DRAX BIOENERGY WITH CARBON CAPTURE AND STORAGE PROJECT

Drax Bioenergy with Carbon Capture and Storage Project, Selby

Prepared for: Huw Williams
 Prepared by: Andy Tennant
 Date: 01/09/2022
 Case Reference: AA.22.11.13
 Document Reference: AA.22.11.13 TM
 Reviewed/approved by: Terry Dale

Drawing file: published-documents / EN010120-000170-6.2.5.6 Drax BECCS ES Vol 2 Figure 5.6 Abnormal Indivisible Load Routing.pdf

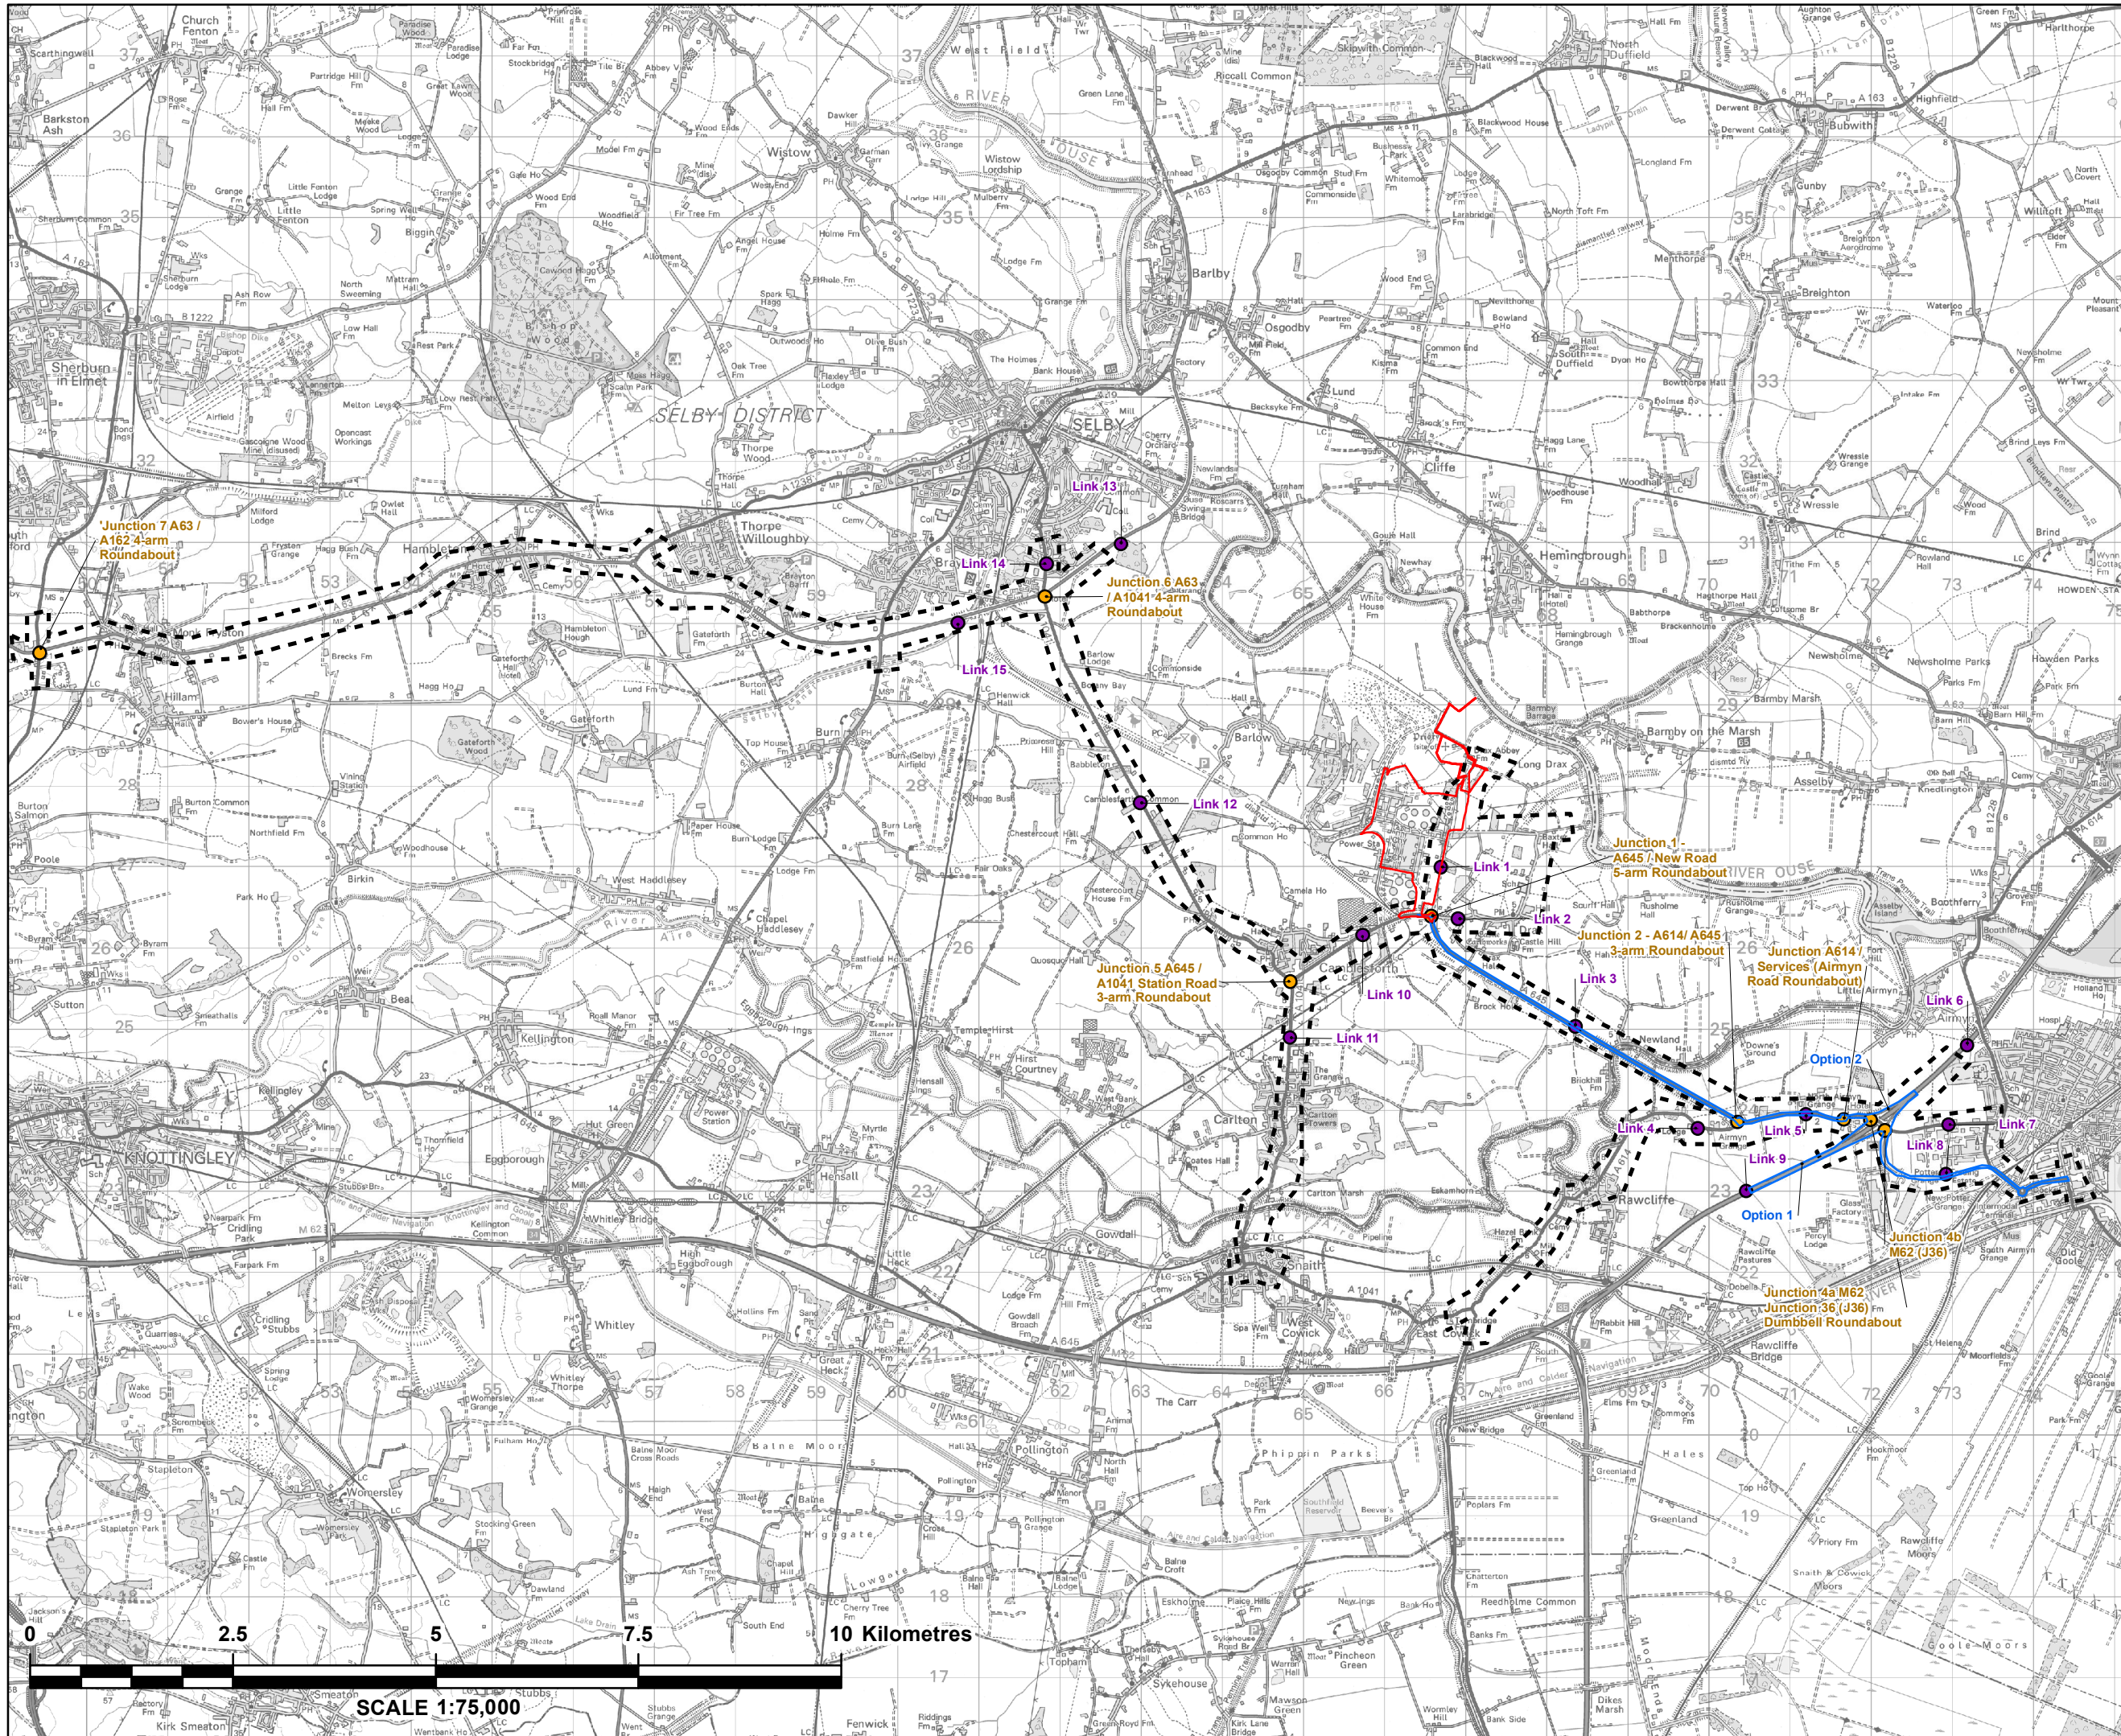
It is proposed that a Highway Condition Survey (HCS) will be carried out along the designated route for abnormal and indivisible loads (AIL) ahead of the first AIL delivery, and after the final AIL. This is with a view to any construction related defects being made good. We support this approach and would request that the surveys be provided to National Highways for review within the Construction Phase Traffic Management Plan; a commitment to make good any defects should also be included in the plan.
